Permit Reviews

Permit Number: **BCOM2603-0006**

Description: **Hispanic Snack Convention Bar**

Site Address: **161 S MCKINLEY ST**

LA COSECHA SNACKS
 161 S McKinley Street, Coats, NC 27521

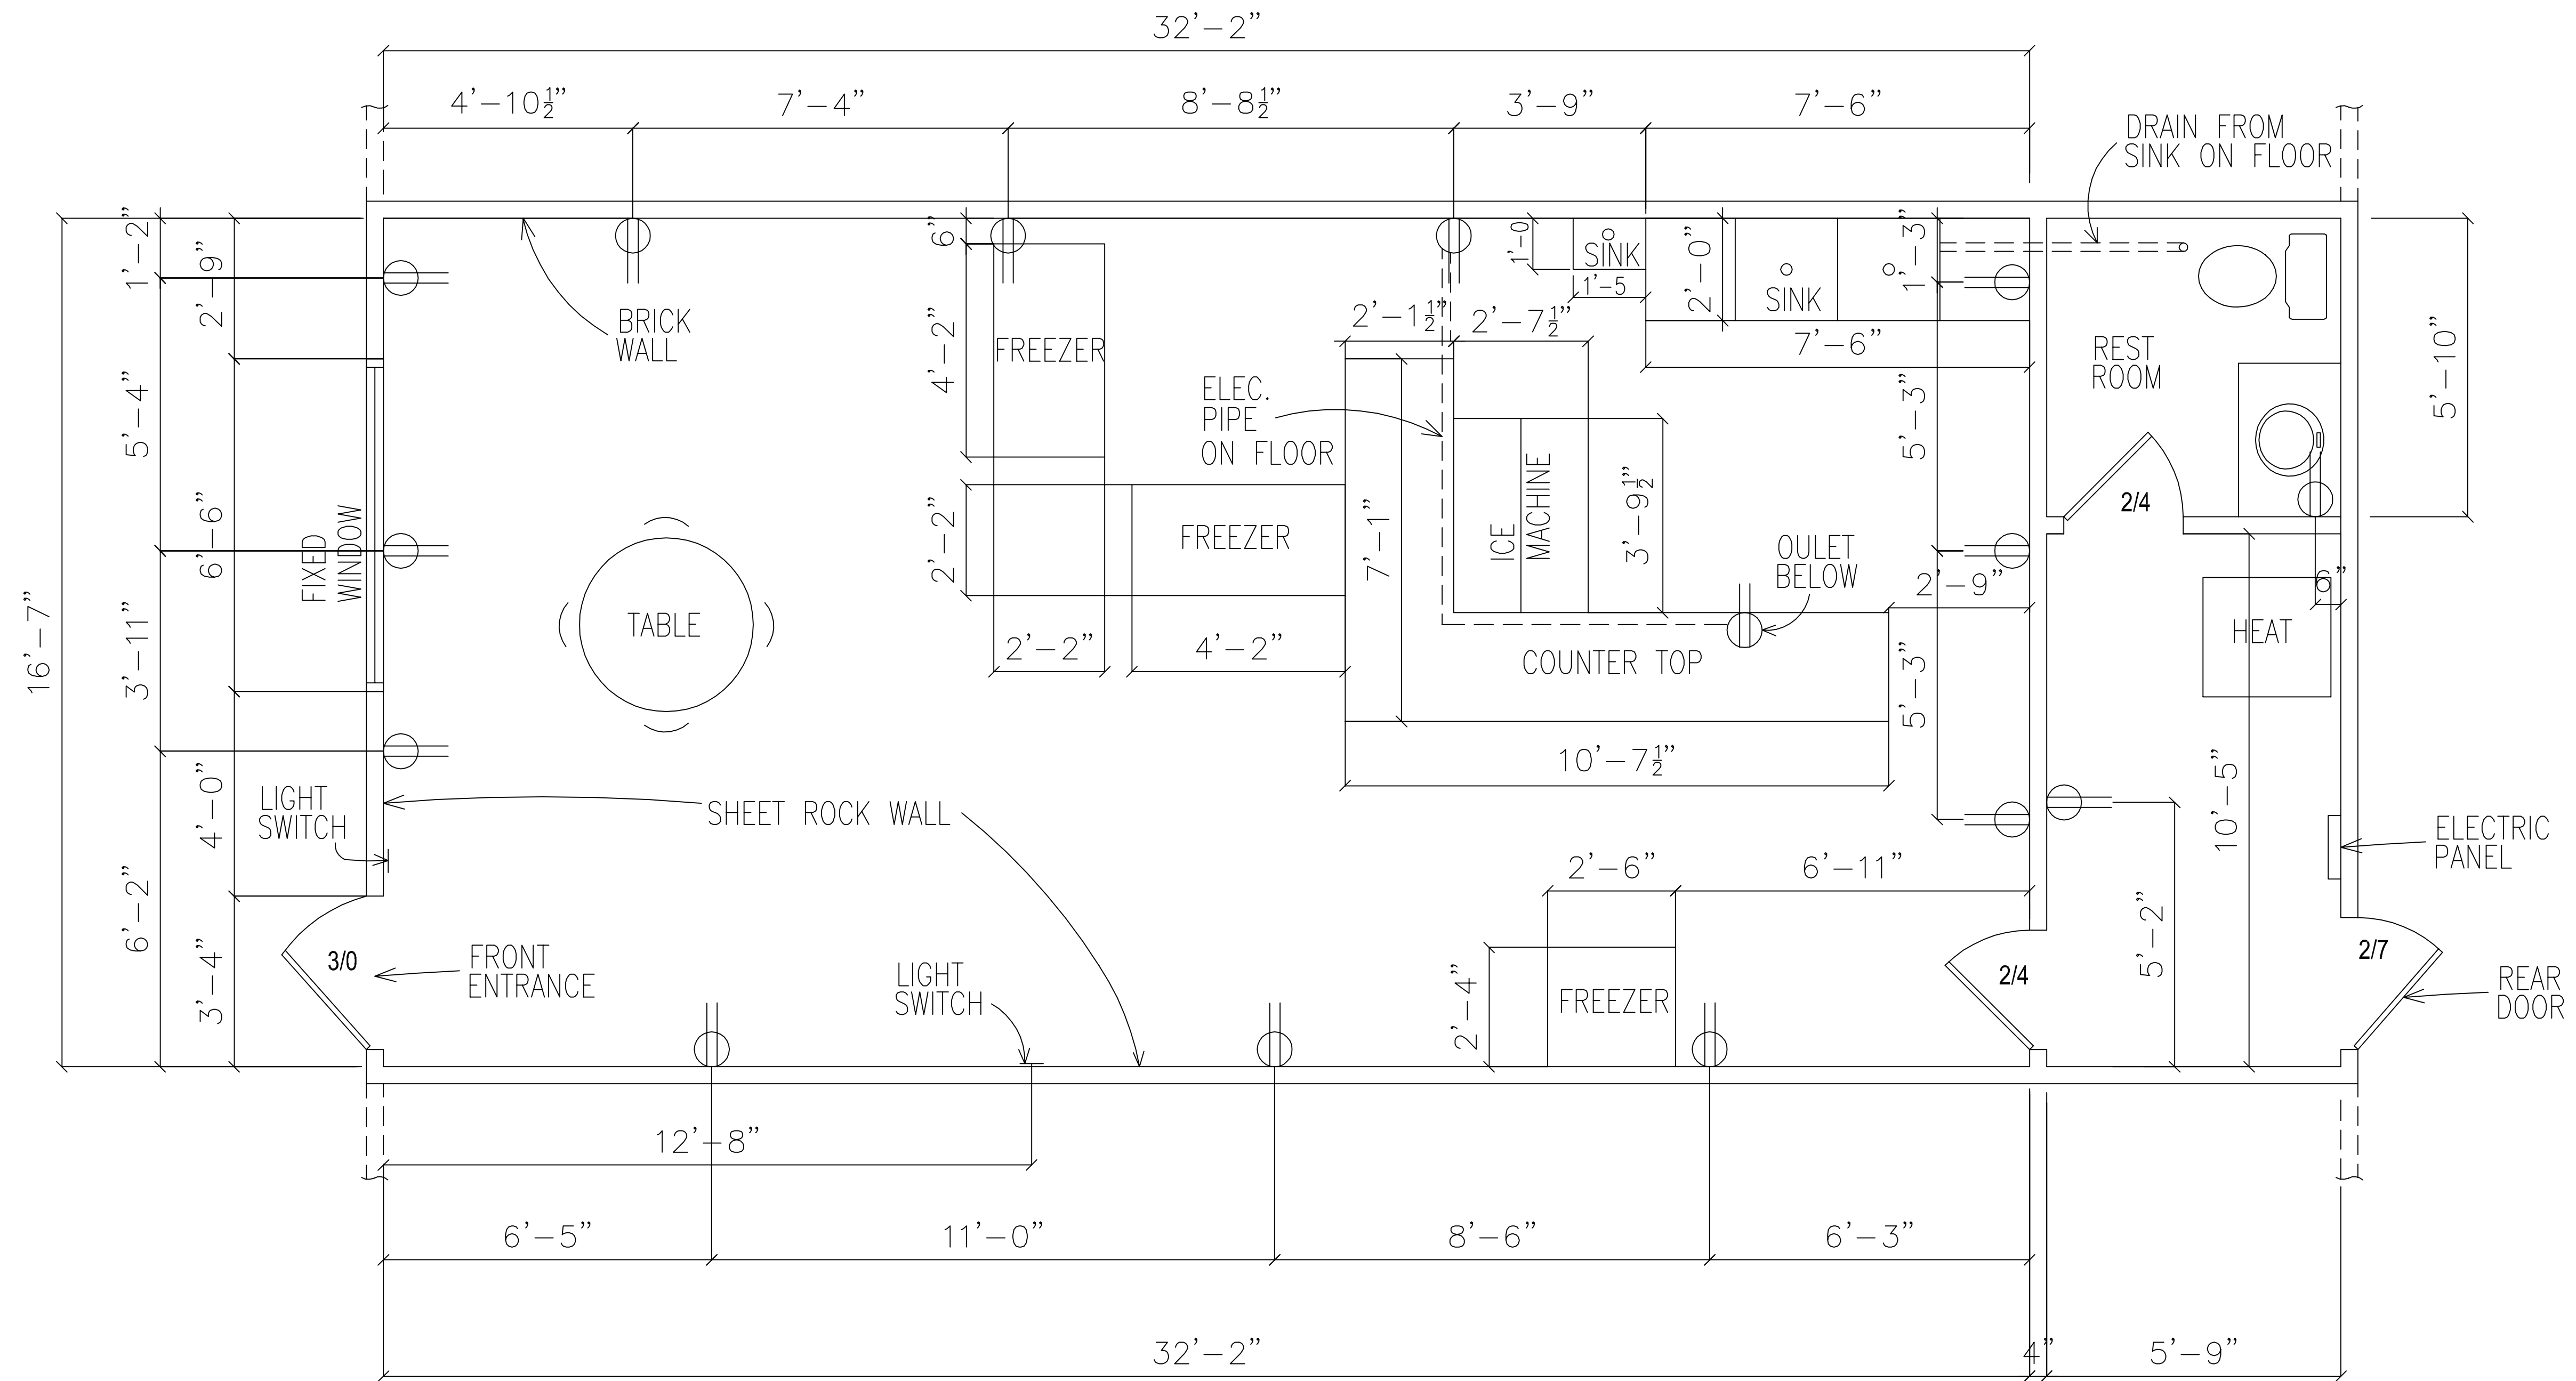
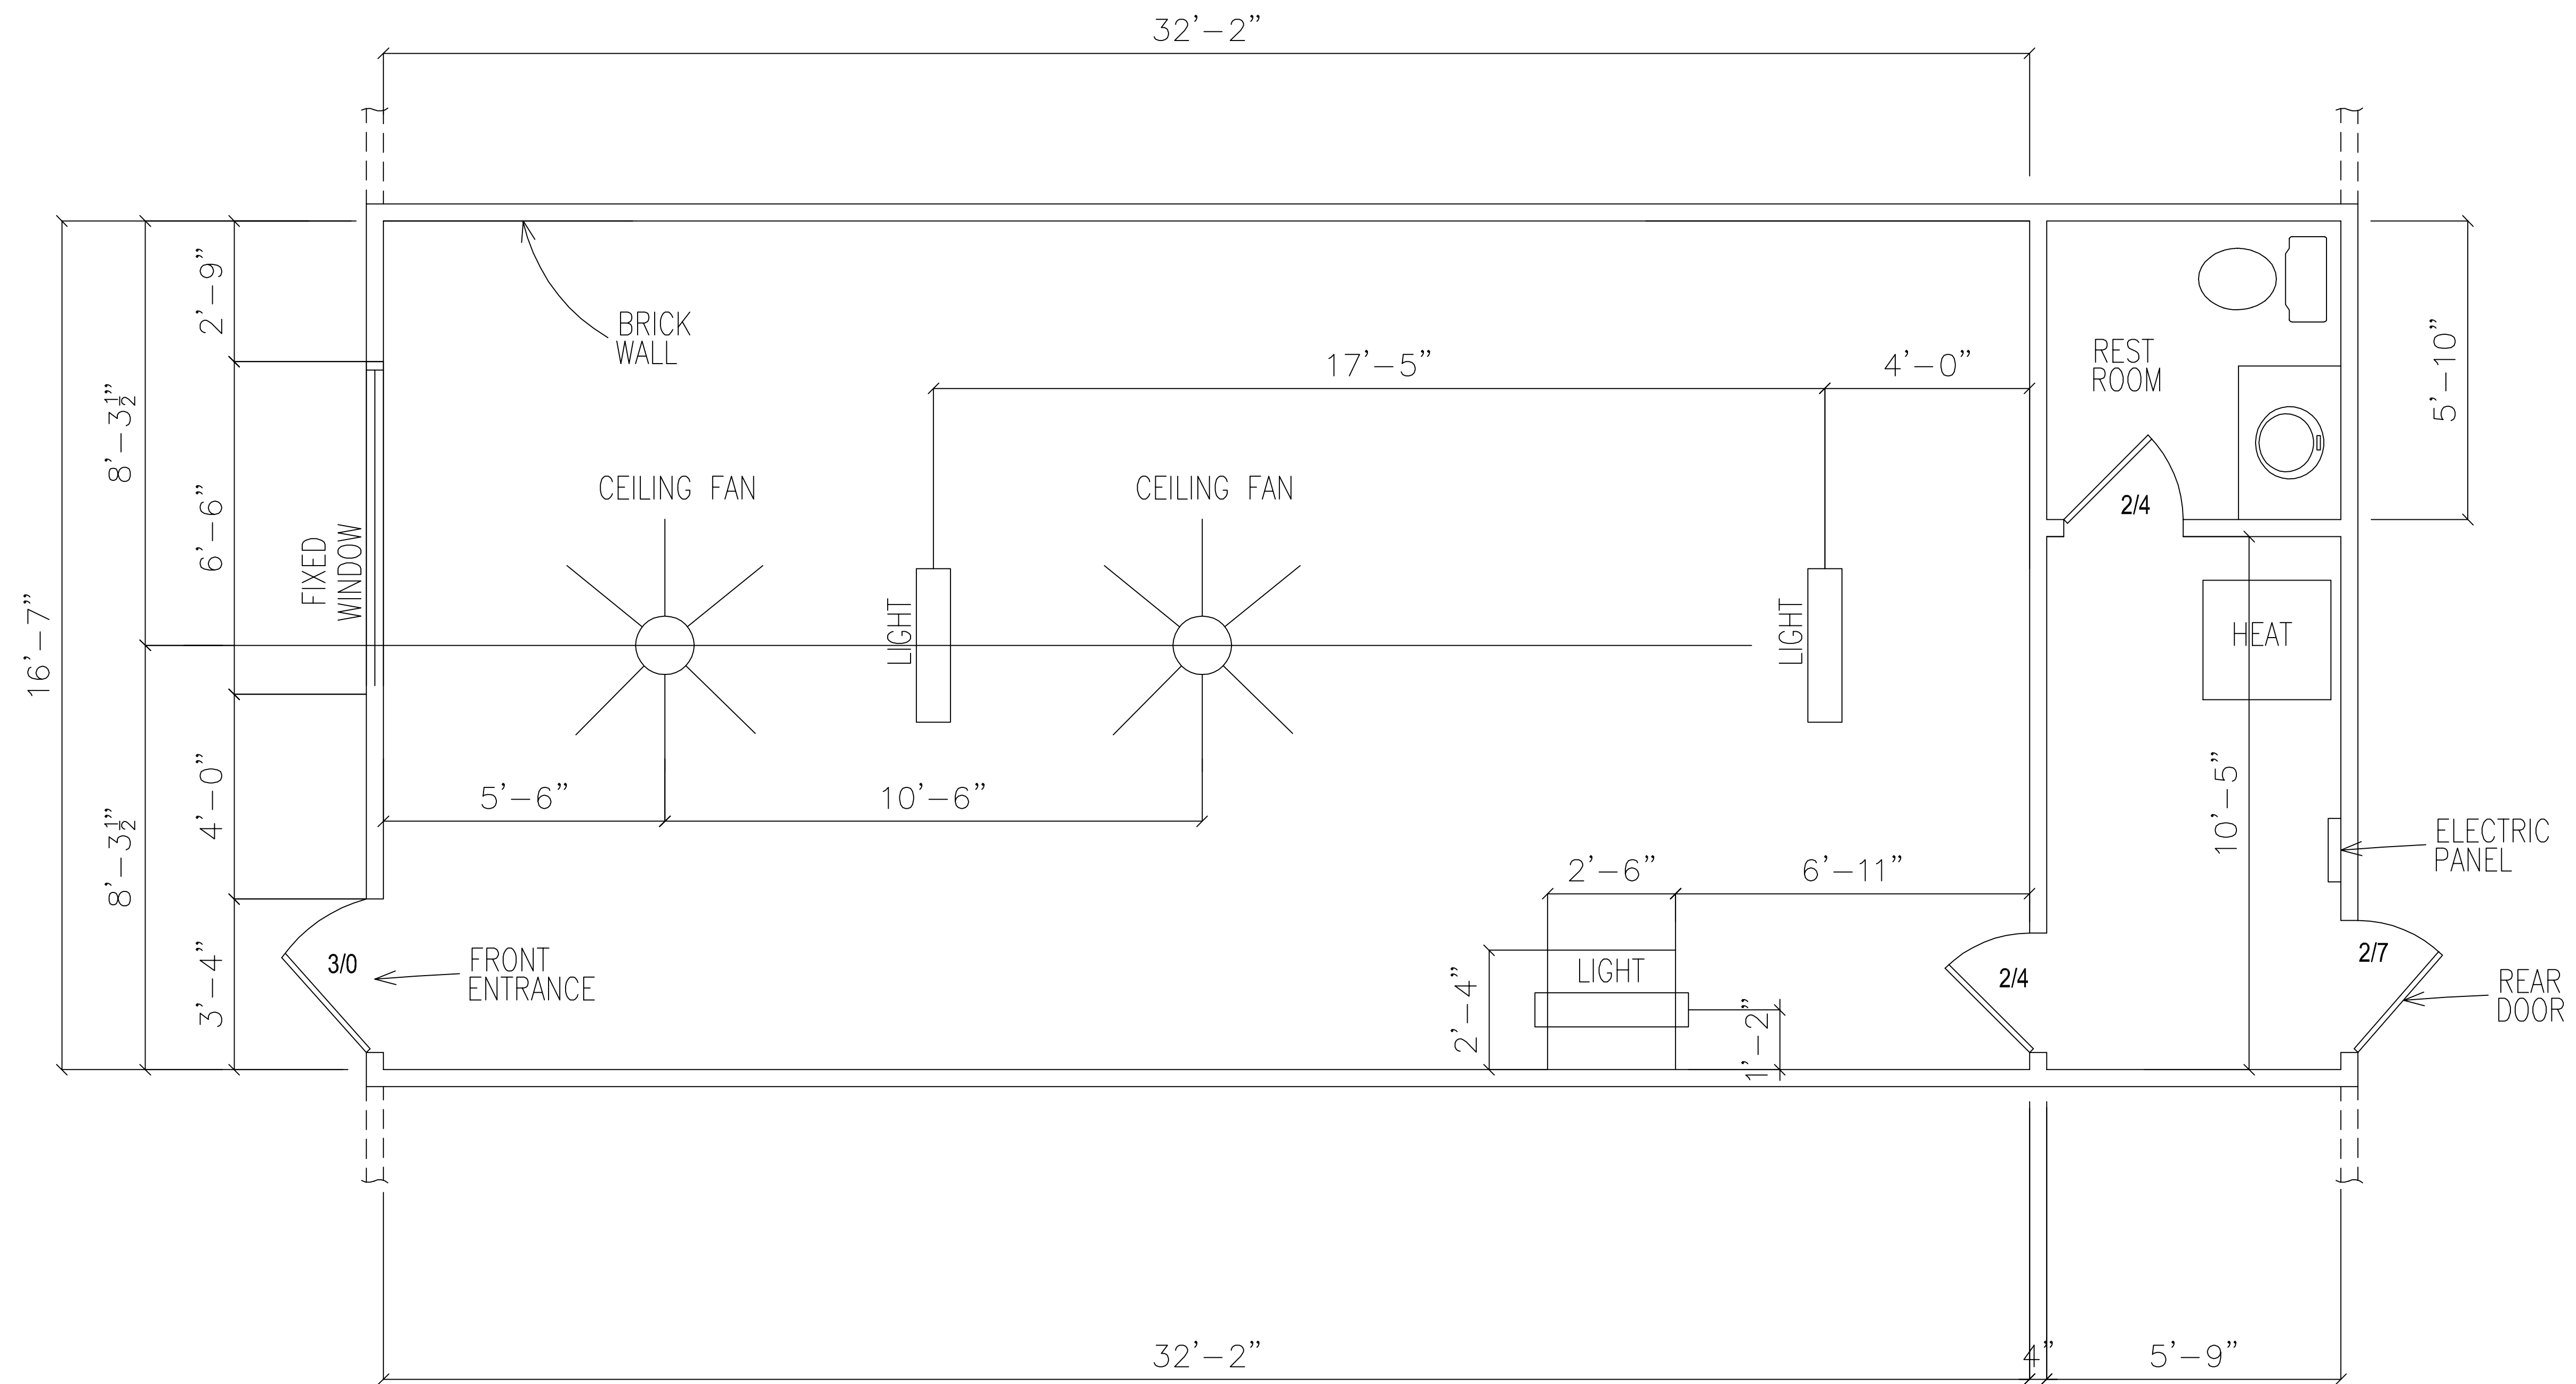
- Life safety plan, fire extinguishers, emergency and exit lighting.
- Cooking hood plans if any cooking or frying will be done.

3/25/2026	4/1/2026	4/9/2026	COMMERCIAL BUILDING REVIEW	Brad Sutton	DISAPPROVED	
<p>Notes:</p> <p>Need a scaled plan Need food details. Cooking? Prepackaged? If cooking, provide hood and cooking equipment details</p>						
4/1/2026	4/20/2026	4/21/2026	COMMERCIAL BUILDING REVIEW	Brad Sutton	DISAPPROVED	
<p>Notes:</p> <p>Customer submitted new life safety plan/site plan. No cooking or frying will take place; fruit will be cleaned & cut up. Cant approve until I know what requirements EH will have for equipment</p>						
5/19/2026	6/2/2026	6/2/2026	COMMERCIAL BUILDING REVIEW	Brad Sutton	DISAPPROVED	
<p>Notes:</p> <p>Waiting for EH and HRW req. Equipment specs, etc</p>						
6/2/2026		6/16/2026	COMMERCIAL BUILDING REVIEW	Building Bucket		
<p>Notes:</p> <p>Menu changed--no longer going through H&S. Customer will be going through NCDA for health regulations.</p>

4/7/2026	4/15/2026	4/21/2026	FIRE MARSHAL	Fire Bucket	APPROVED	See attached letter
<p>Notes:</p> <p>-Customer confirmed that exit signs & lighting are above exits on new life safety plan/site plan. Fire extinguisher is shown on new plan. -No cooking or frying will take place; fruit will be cleaned & cut up.</p> <p>See attached letter.</p>						
4/15/2026	4/15/2026	4/15/2026	HEALTH AND SANITATION	Cynthia Pierce	DISAPPROVED	
<p>Notes:</p> <p>Application incomplete, site plan not adequate or drawn to scale, need equipment spec sheets, need food process sheets. Emailed sent to applicant requesting information, application sent back via email.</p>						
Review Group: 2ND PLAN REVIEW						
4/28/2026	4/30/2026	5/12/2026	HEALTH AND SANITATION	Cynthia Pierce	DISAPPROVED	
<p>Notes:</p> <p>I spoke with Amelia on 4-30. Discussed the following: Newly submitted information is not adequate and additional information is needed. Missing completed food service application. Applicant turned in 4 pages. Turn in entire FS application completed. Site plan drawn to scale missing. Equipment specification sheets missing or not adequate. Recommended applicant hire a restaurant consultant to help her with the plan review submittal process.</p>

3. 3-Compartment Sink:
 - a. Brand – Serv-Ware
 - b. Model # - E3CWP18182-18

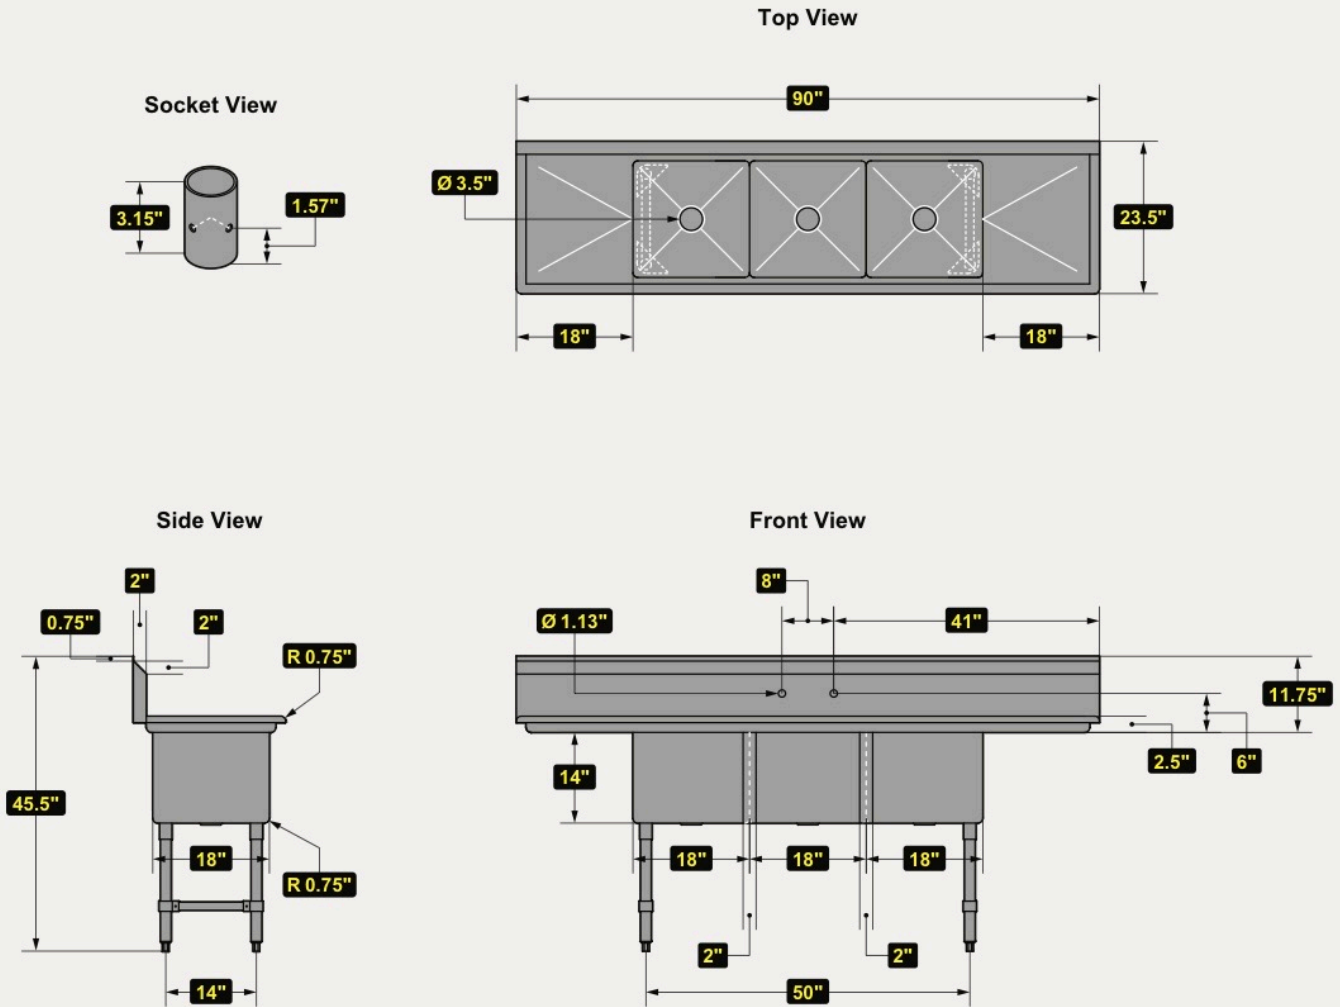
1. You install a minimum of a 50 GPM poly grease trap on the 3-compartment sink. All compartments will be plumbed to the trap. If additional kitchen or prep sinks are installed, you will be required to install additional traps.
